# APPLICATION BY NATIONAL HIGHWAYS FOR AN ORDER GRANTING DEVELOPMENT CONSENT FOR THE A66 NORTHERN TRANS-PENNINE PROJECT

Submission on behalf of Cumbria & Lakes Joint Local Access Forum in accordance with Deadline 1 (18 December 2022).

Drawing Title  
**Land Plans  
Regulation 5(2)(i)  
Sheet 2 of 4**

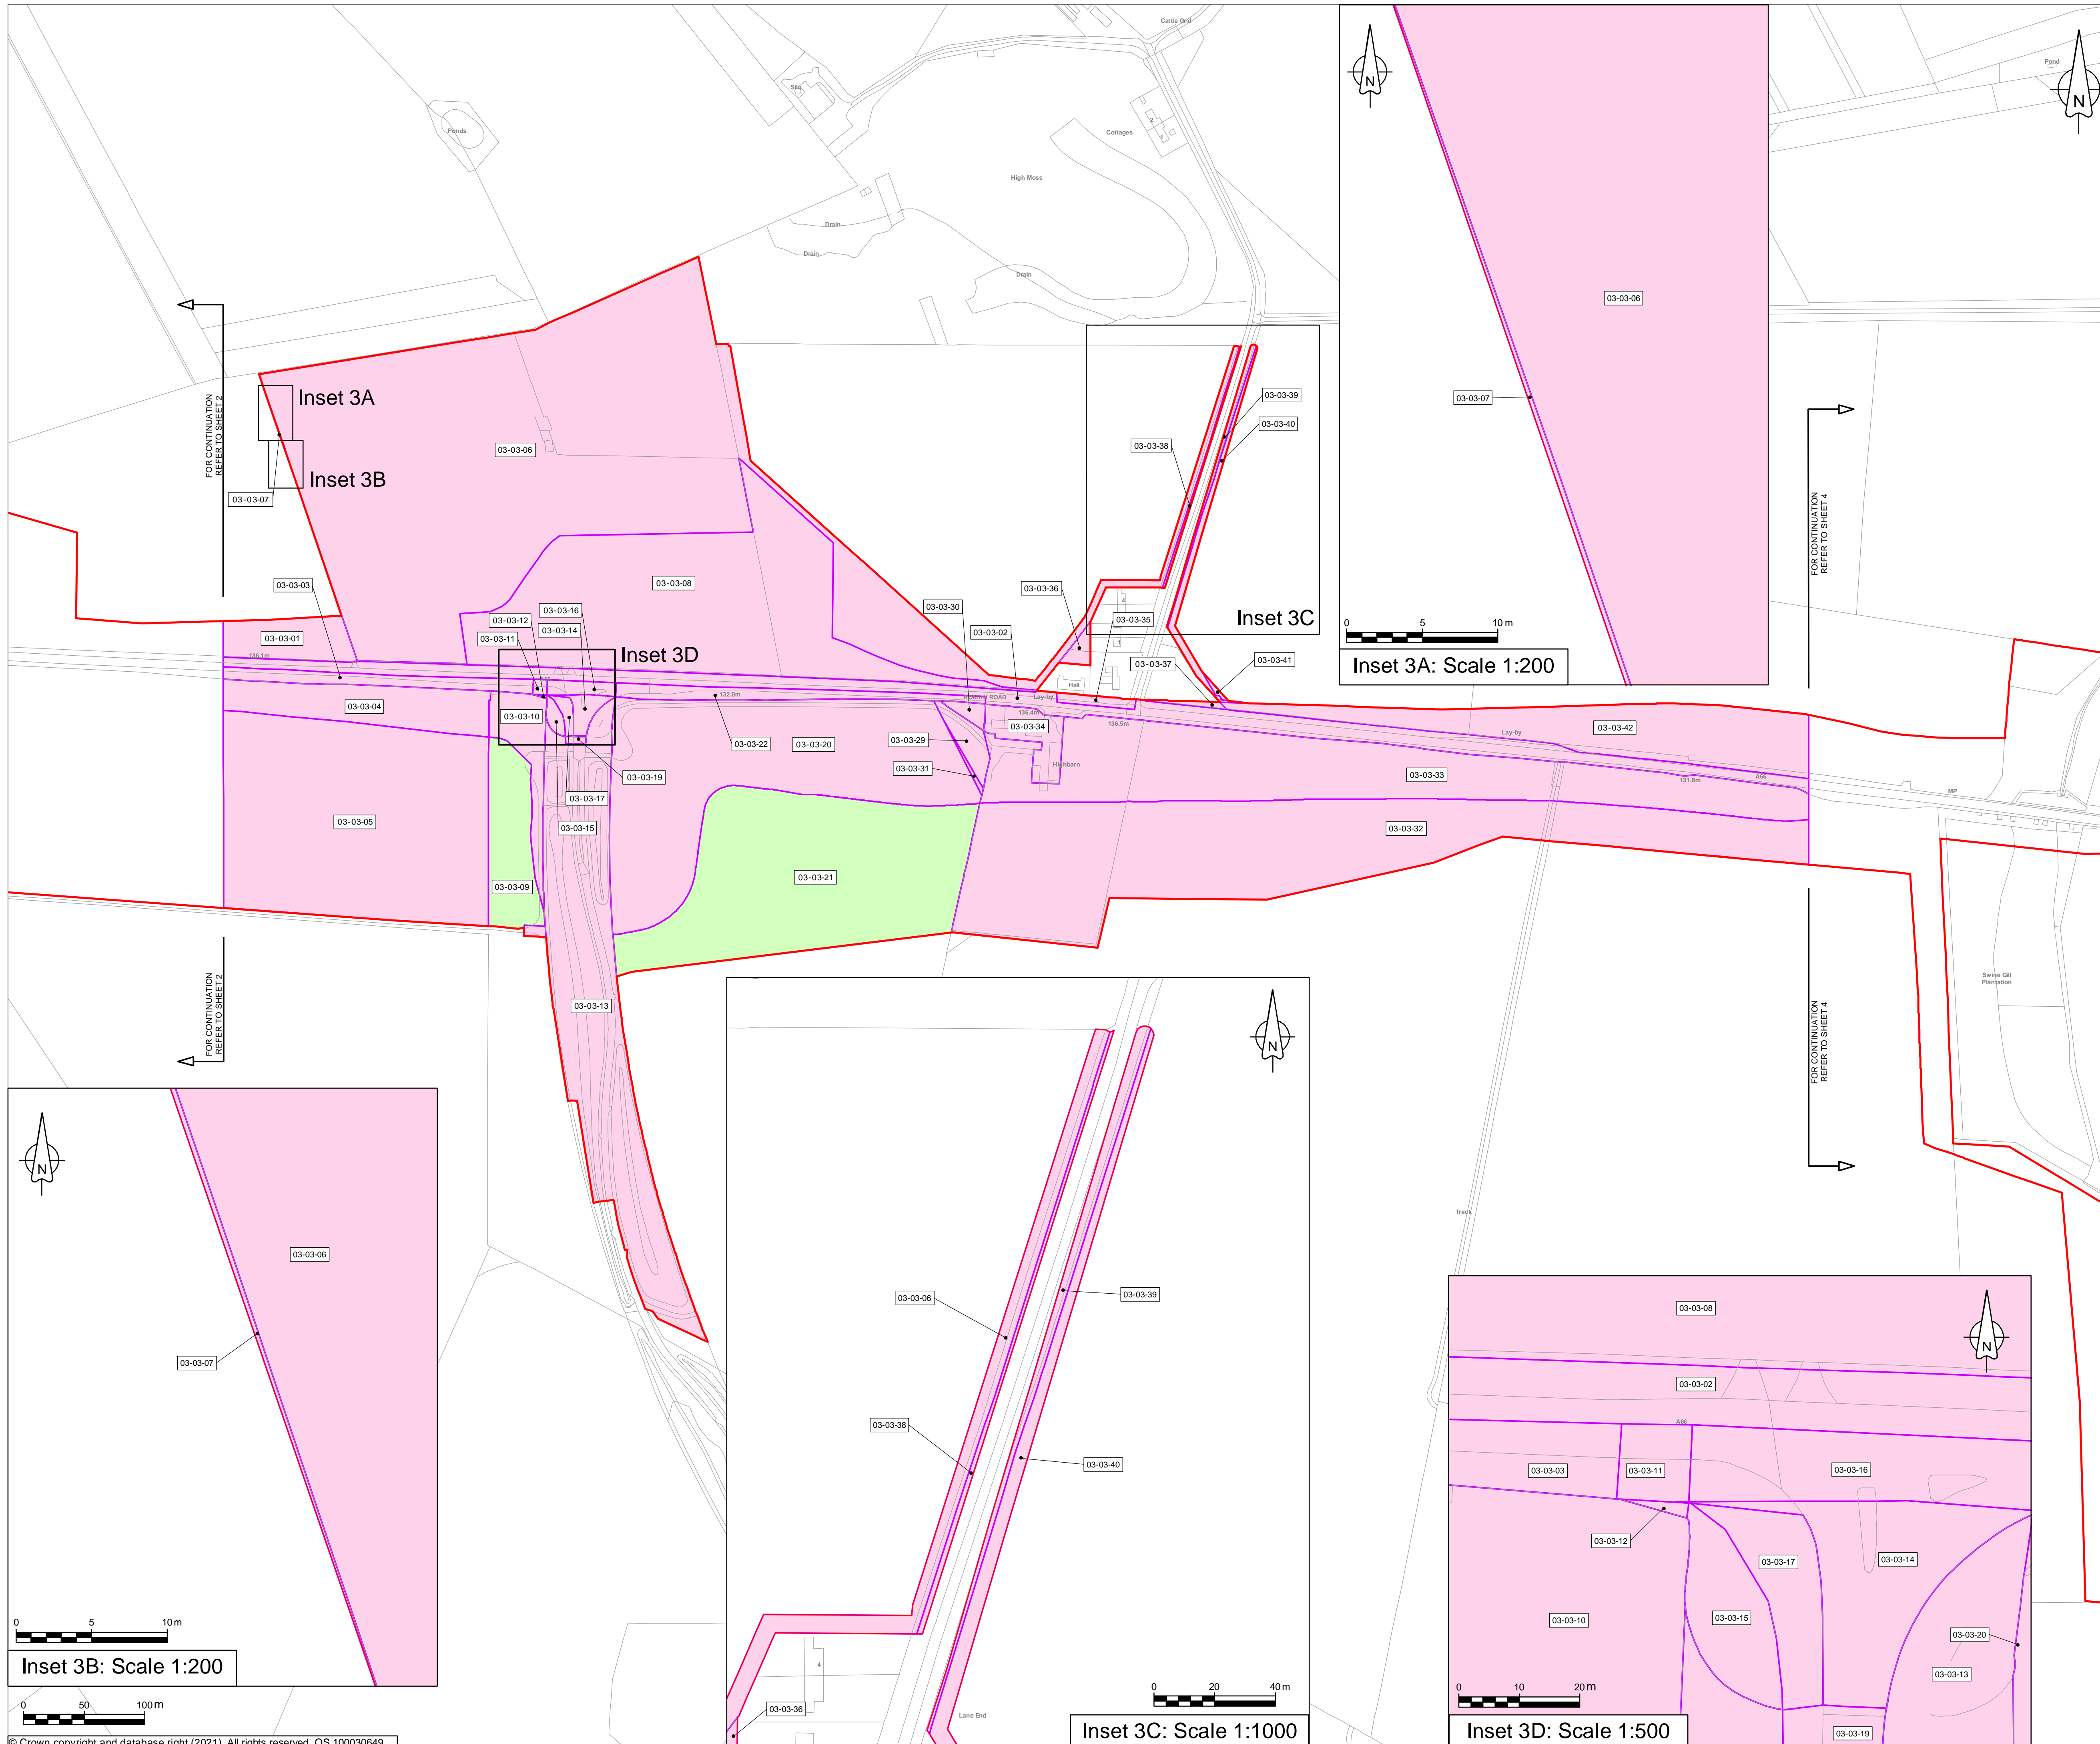
- 9.2 On sheet 2 of scheme 03, at the realigned junction with byway open to all traffic 311013 to Ninekirks (ref G on sheet 2), no provision is made for access from the westbound carriageway, but private crossing of the carriageway is provided by underpass which could usefully be employed to provide access to the byway from the westbound carriageway.
